From: Holly Duncan
Sent: Monday, April 23, 2012 11:13 AM
To: Jeff Watson
Subject: RE: BL-12-00007 Mahre

From: Jeff Watson
Sent: Wednesday, April 18, 2012 10:36 AM
To: Christina Wollman; Brenda Larsen; Jan Ollivier; Holly Duncan
Cc: Chris Cruse (cruseandassoc@kvalley.com)
Subject: BL-12-00007 Mahre

Map Center: Township:17 Range:19 Section:33

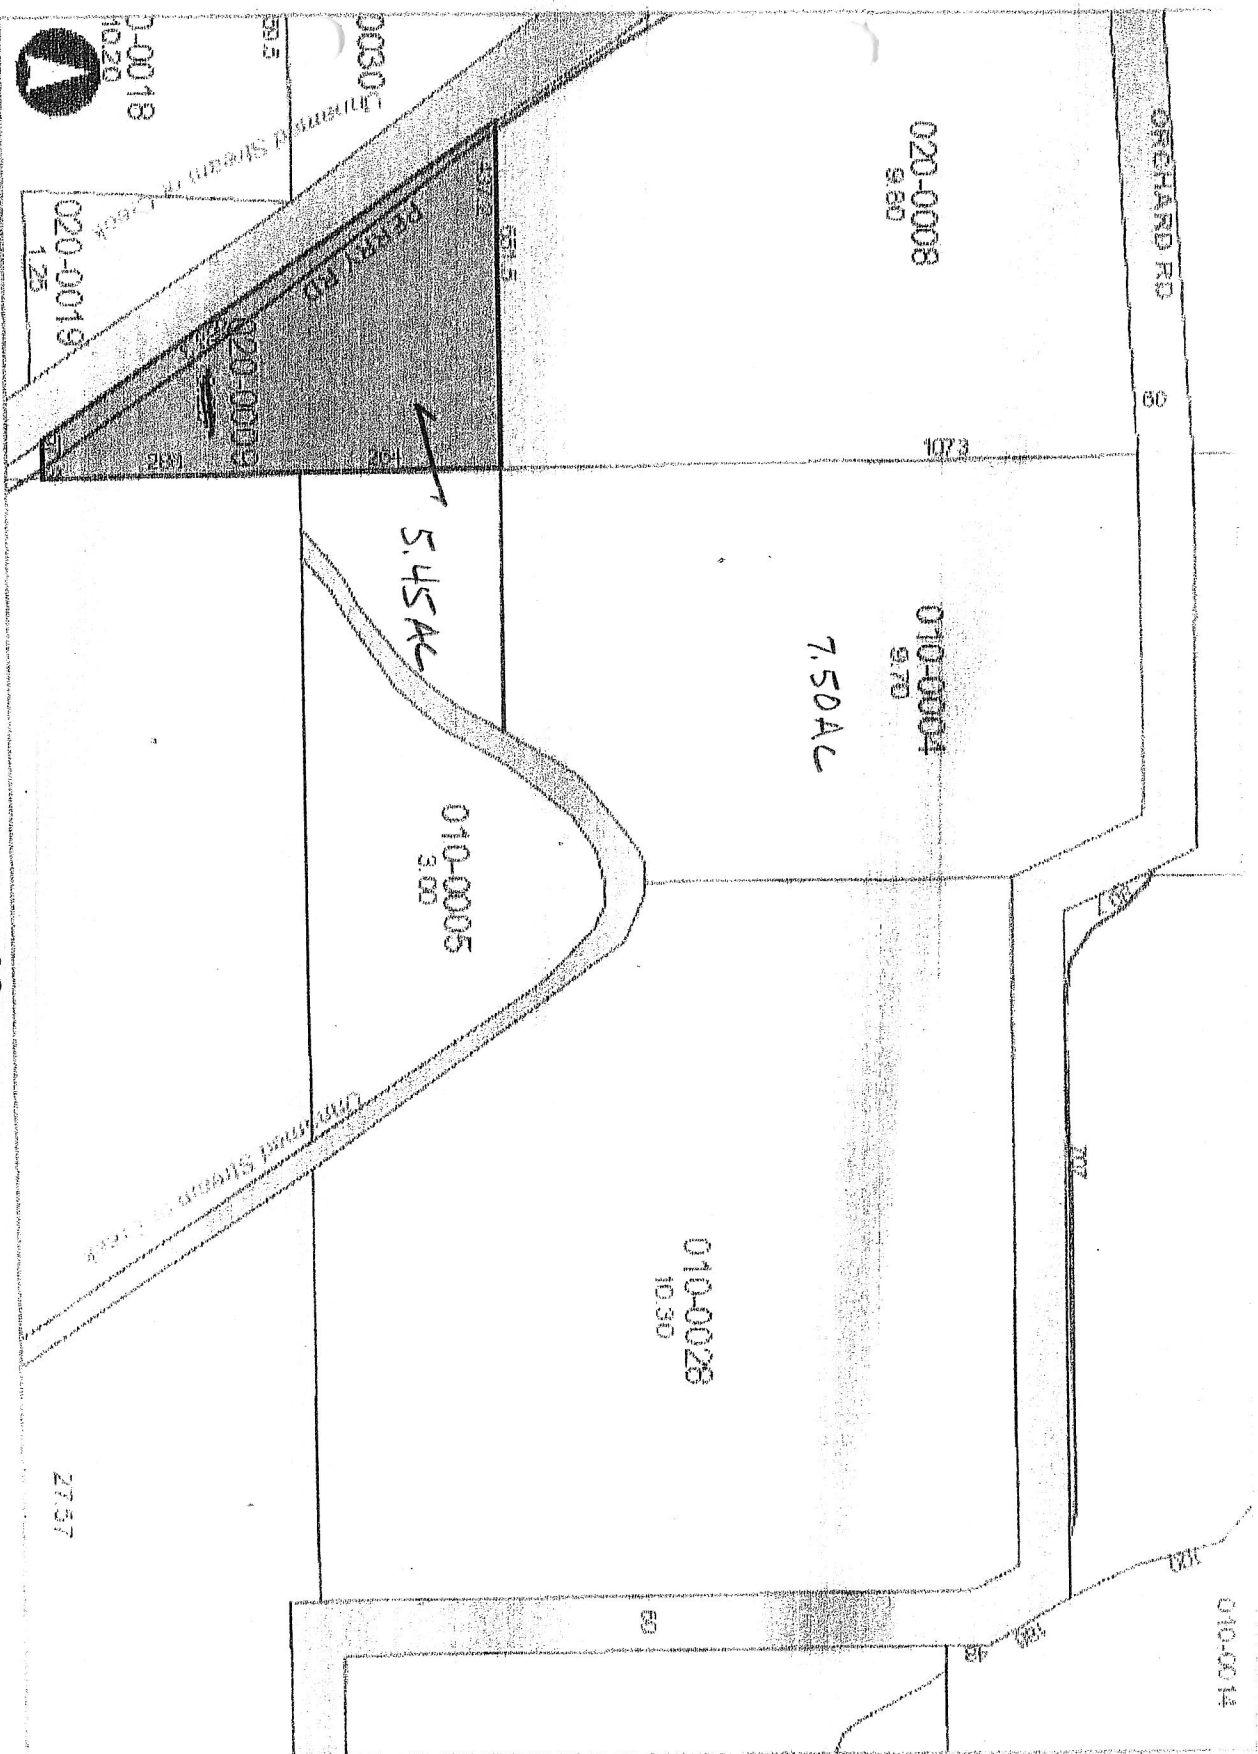
It doesn't appear that the new line will come within 50 feet of any existing wells or septic systems.
